Project: 22_131 : Echelon Dub 30 Grid Connection **File No:** 22_131MEMO-22_131-001

Subject: Section 146b Design Amendments Summary **Date:** 05/02/2026

22_131 - CSE - GEN - XX - DR - C - 15110

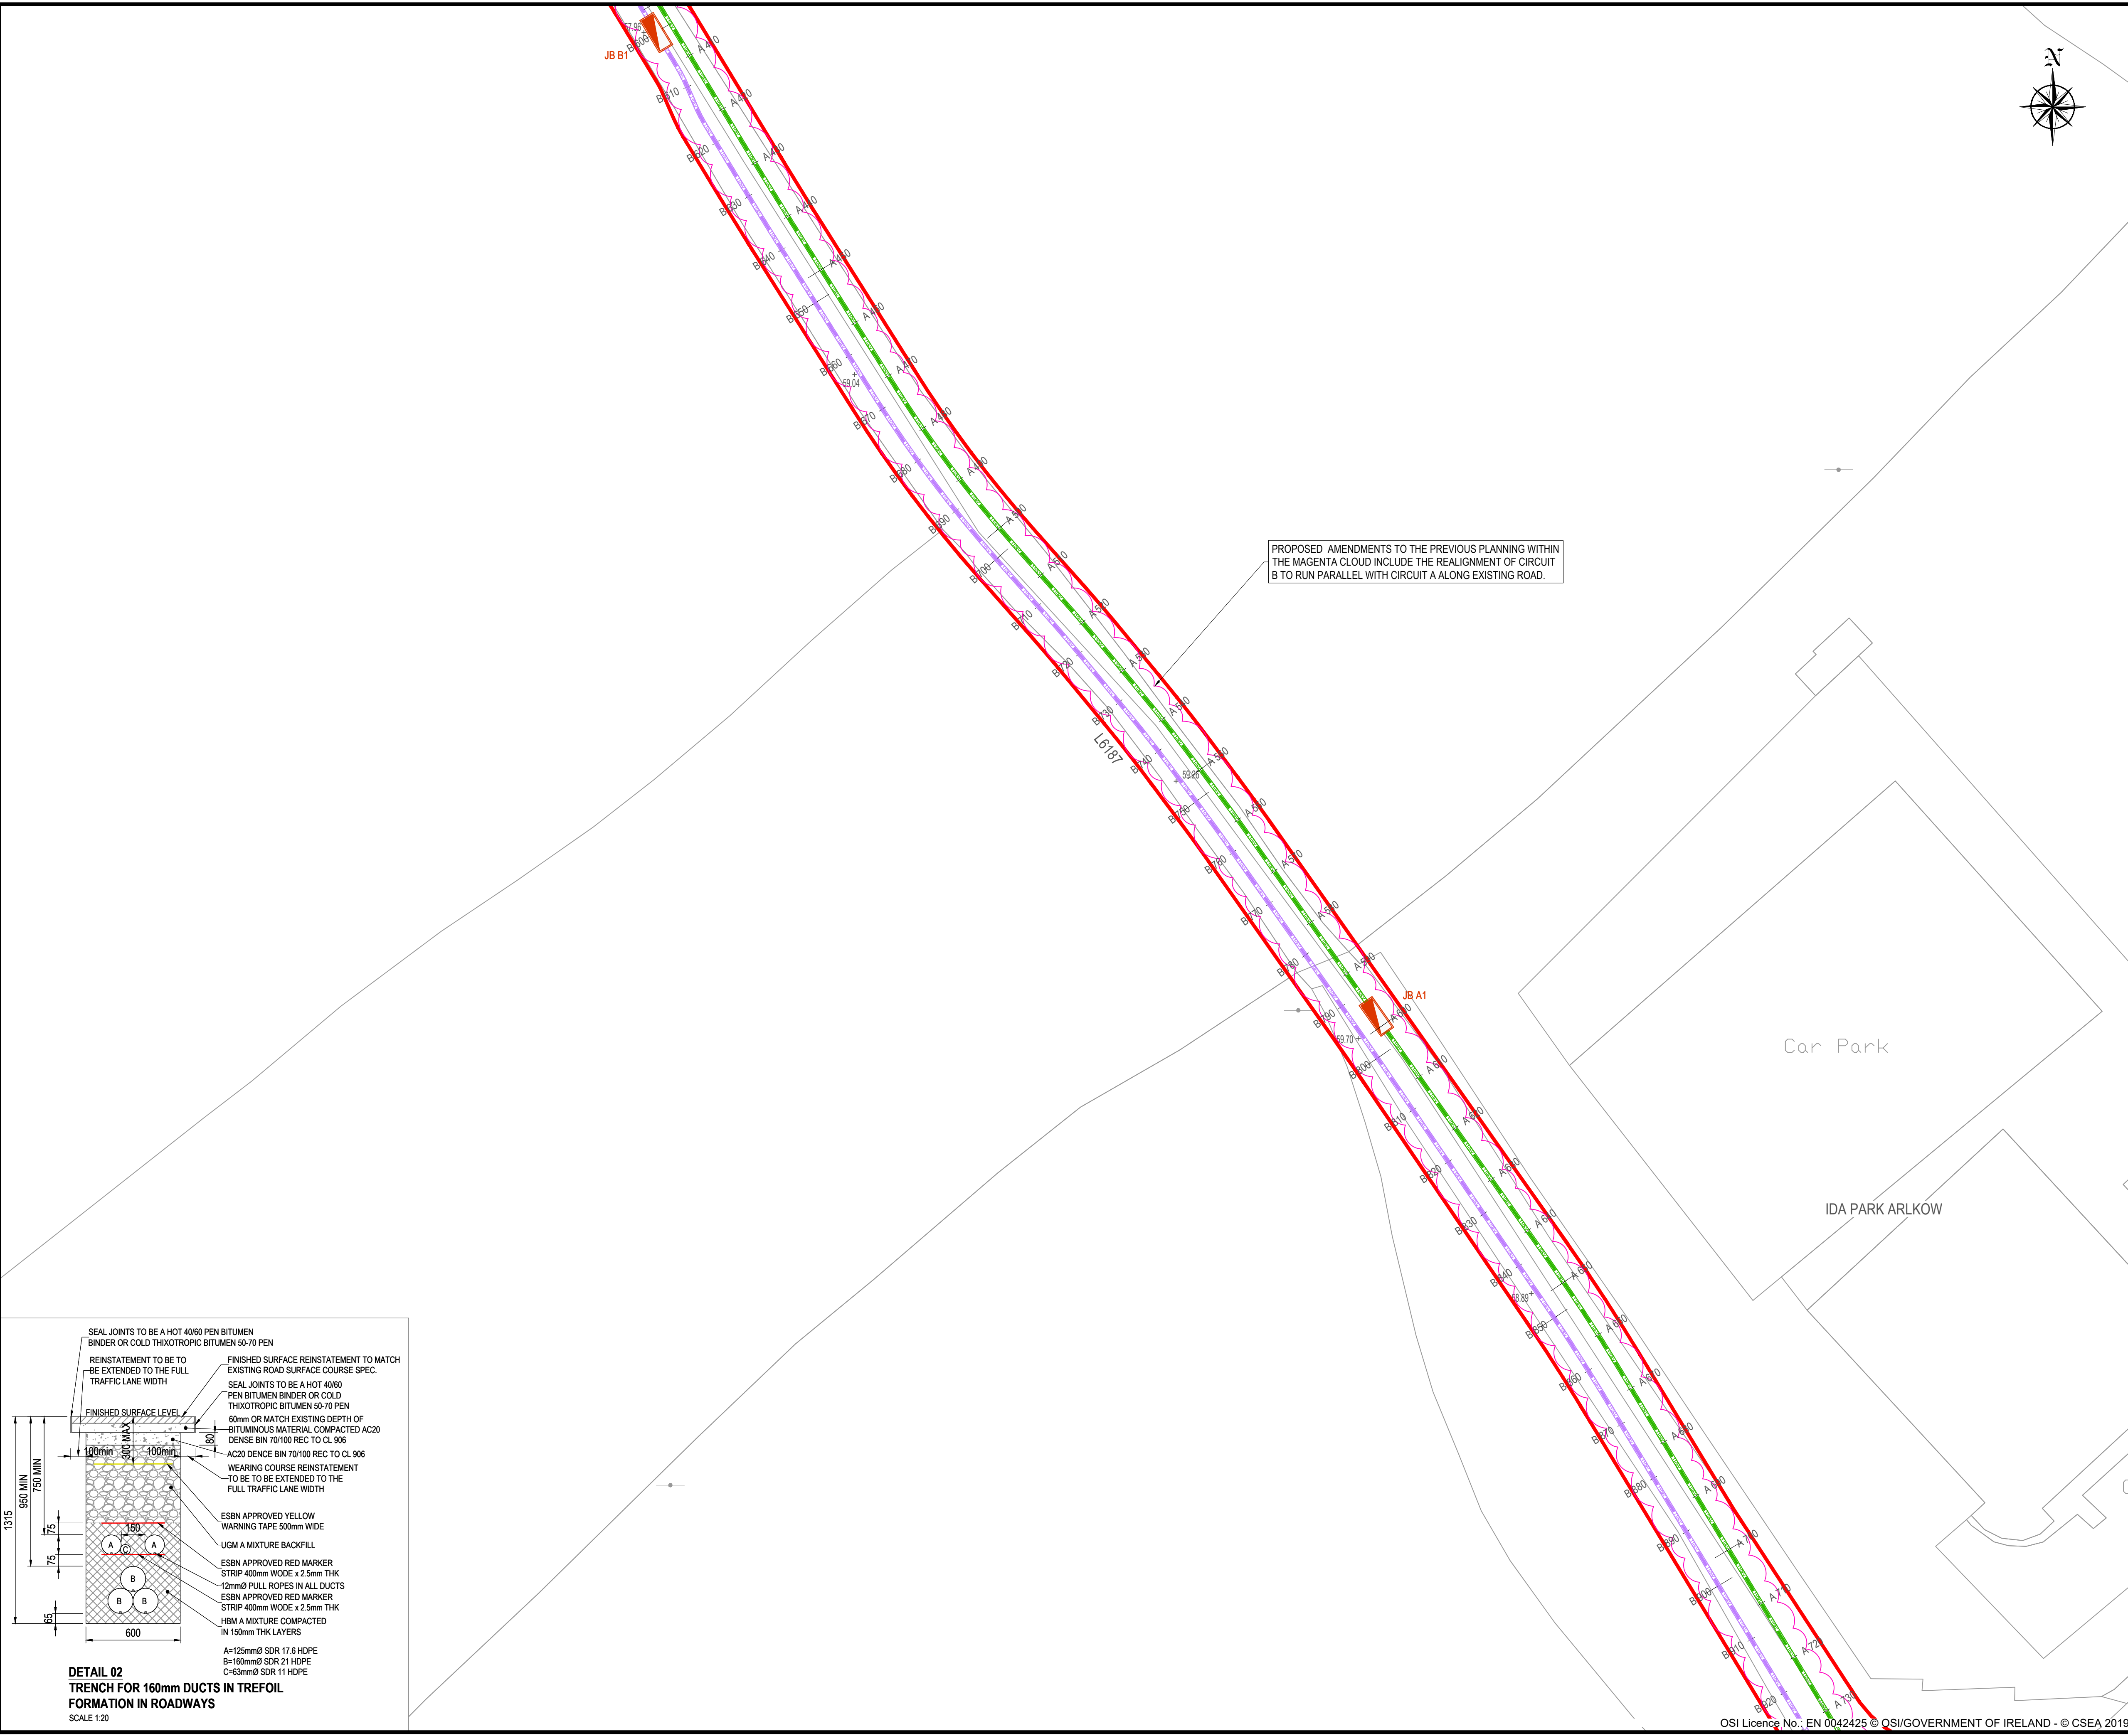
The proposed Circuit A follows the permitted alignment from the proposed drop-down masts at Chainage 0+000, traversing along the existing L6187 road, crossing under the M11 Motorway at Junction 21, and continuing northwest of the existing R772 road until Chainage 2+000. From this point, the alignment of Circuit A is amended to traverse agricultural lands adjacent to the R772 until Chainage 2+650, where it rejoins the permitted route. Circuit A then crosses under the existing IÉ railway infrastructure via HDD and proceeds to the proposed GIS Substation.

The proposed Circuit B alterations involve changes to the permitted alignment between the proposed drop-down masts at Chainage 0+000 and Chainage 2+450, where the route rejoins the permitted alignment. Circuit B is realigned to traverse the existing L6187 road and run in parallel to Circuit A, crossing under the M11 Motorway at Junction 21, and continuing northwest of the existing R772 road until Chainage 1+800. From this point, Circuit B traverses agricultural lands adjacent to the R772 until it rejoins the permitted alignment at Chainage 2+450. Circuit B then crosses under the existing IÉ railway infrastructure via HDD and proceeds to the proposed GIS Substation.

In addition to these alterations, the location of the permitted drop-down masts has been adjusted slightly to facilitate the realignment of the proposed Circuit B.

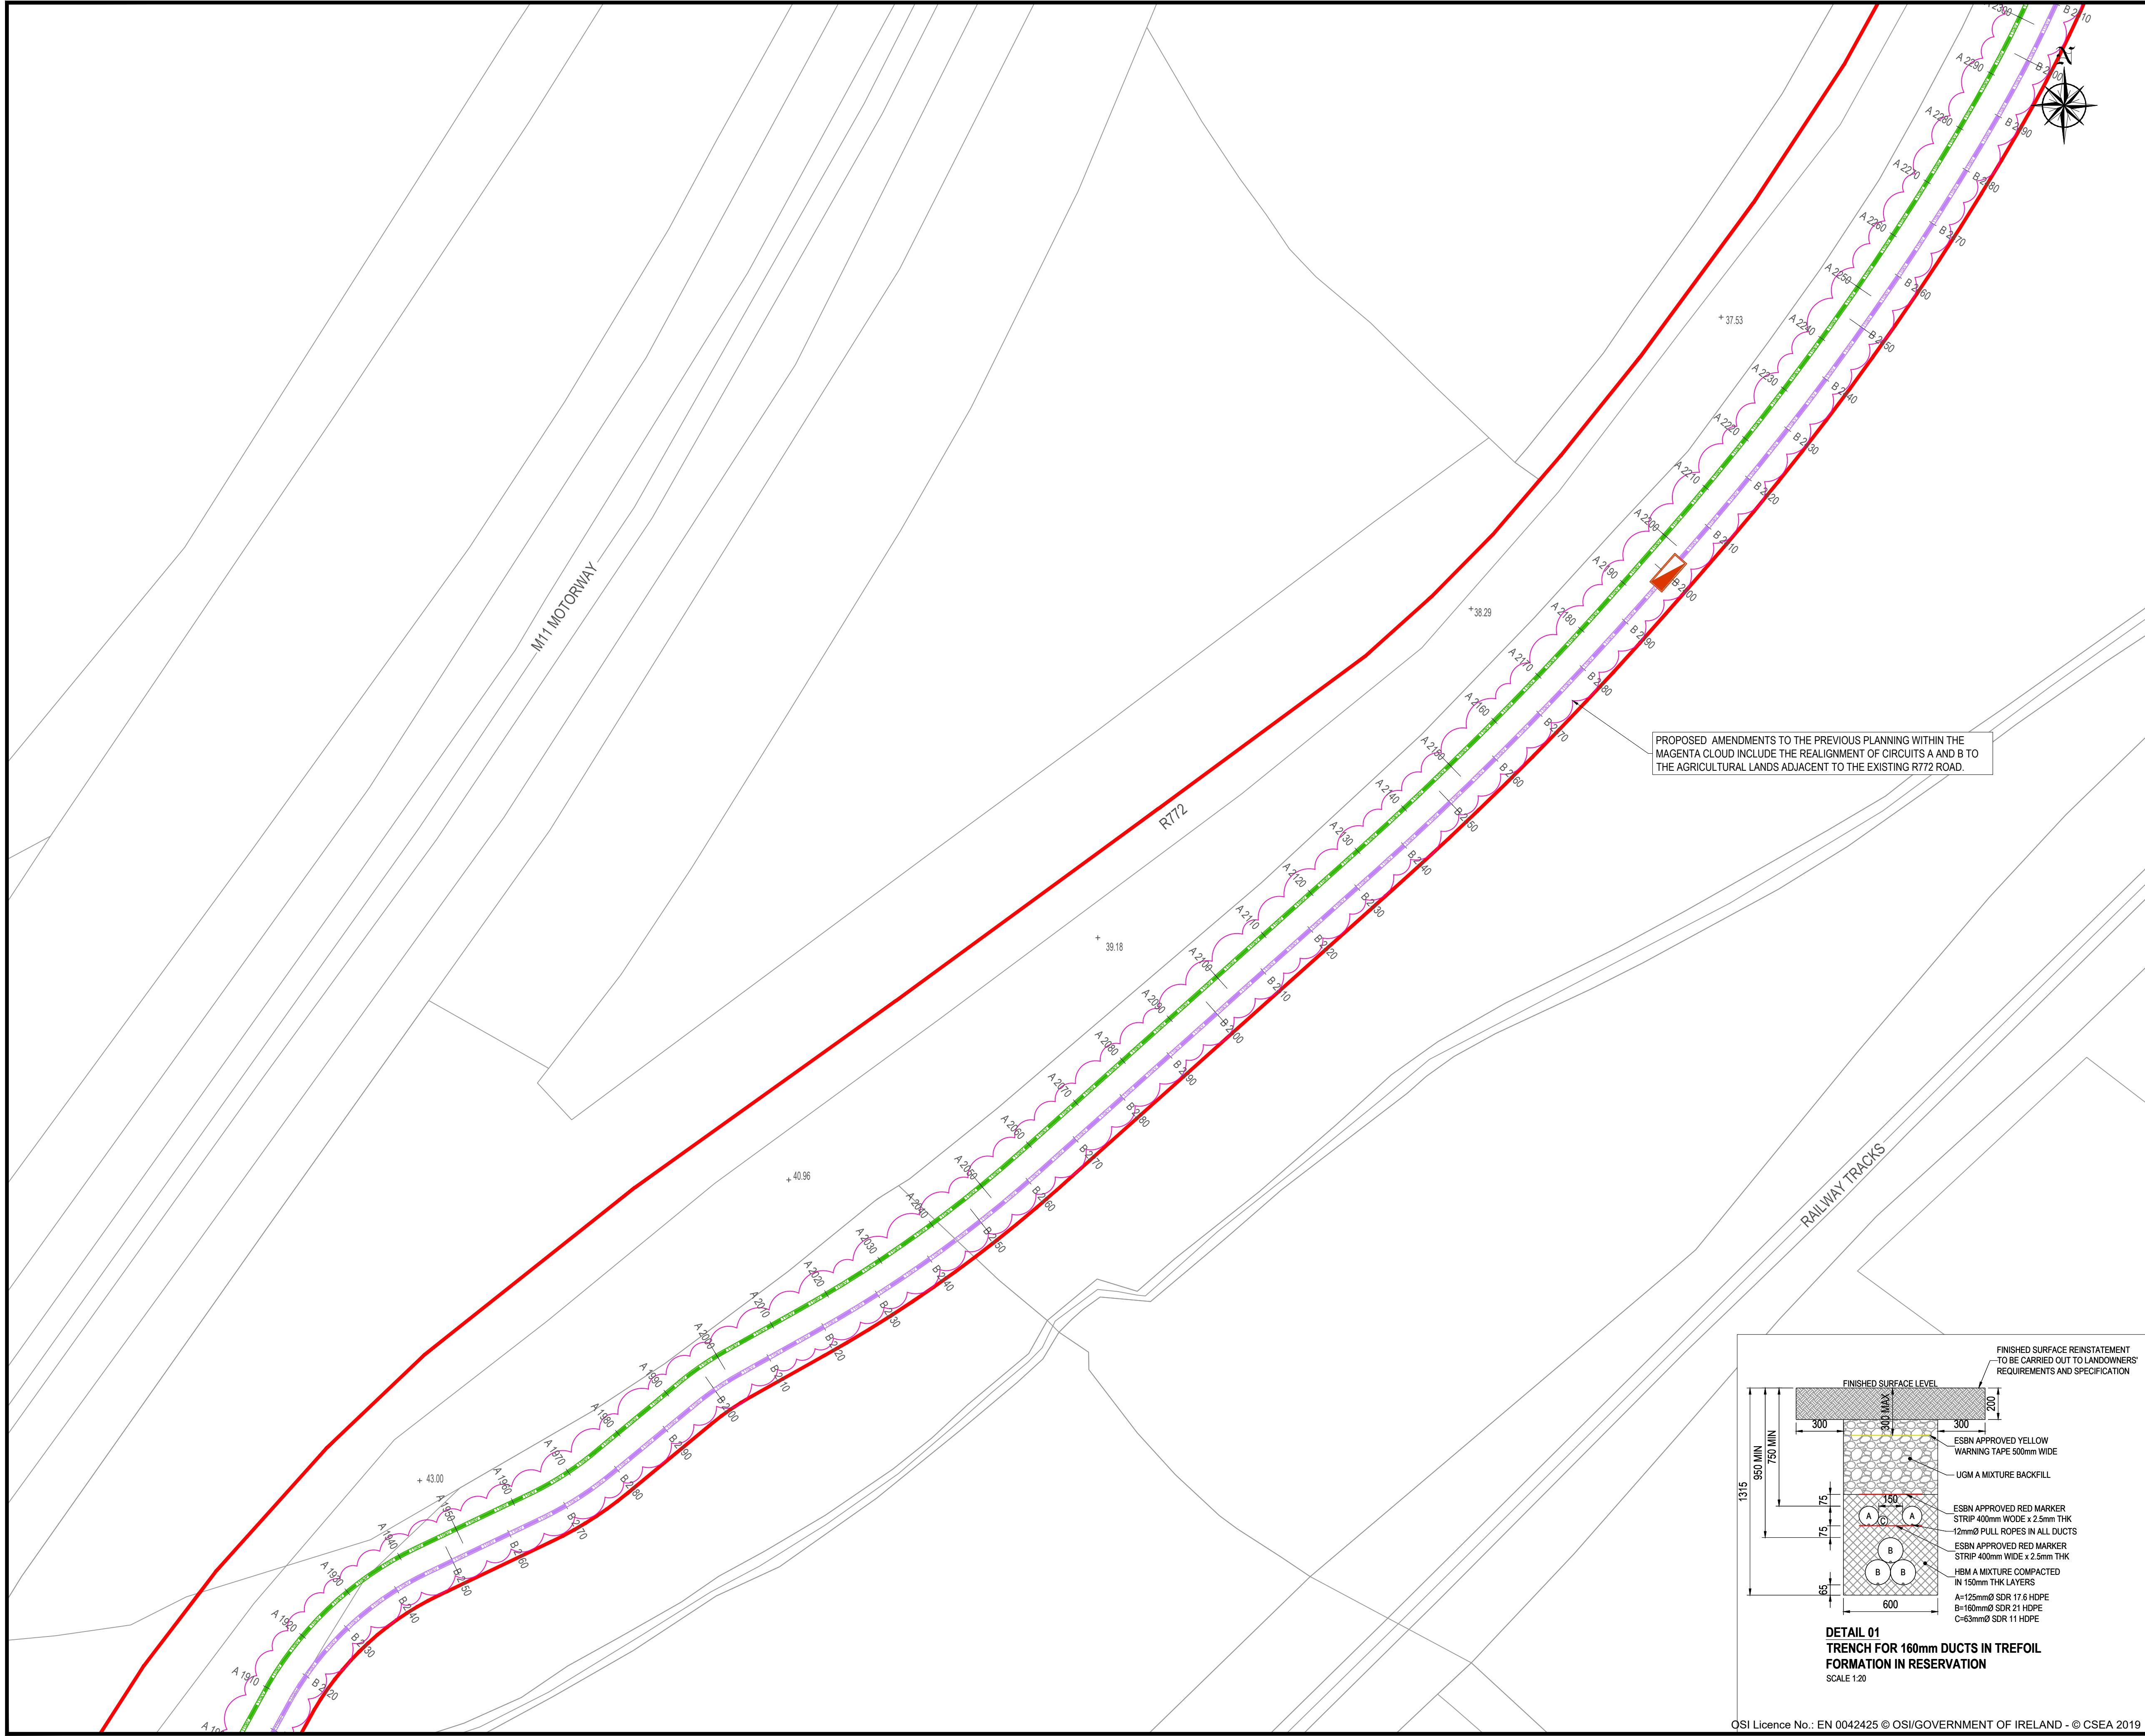
The proposed amendments are intended to minimise the land take required for the circuits and remove the HDD crossing under the existing M11 Motorway. While these changes result in a slight increase in the overall length of Circuits A and B, they reduce impacts on adjacent private lands and avoid works on the recently upgraded R772 road as requested by Wicklow County Council.
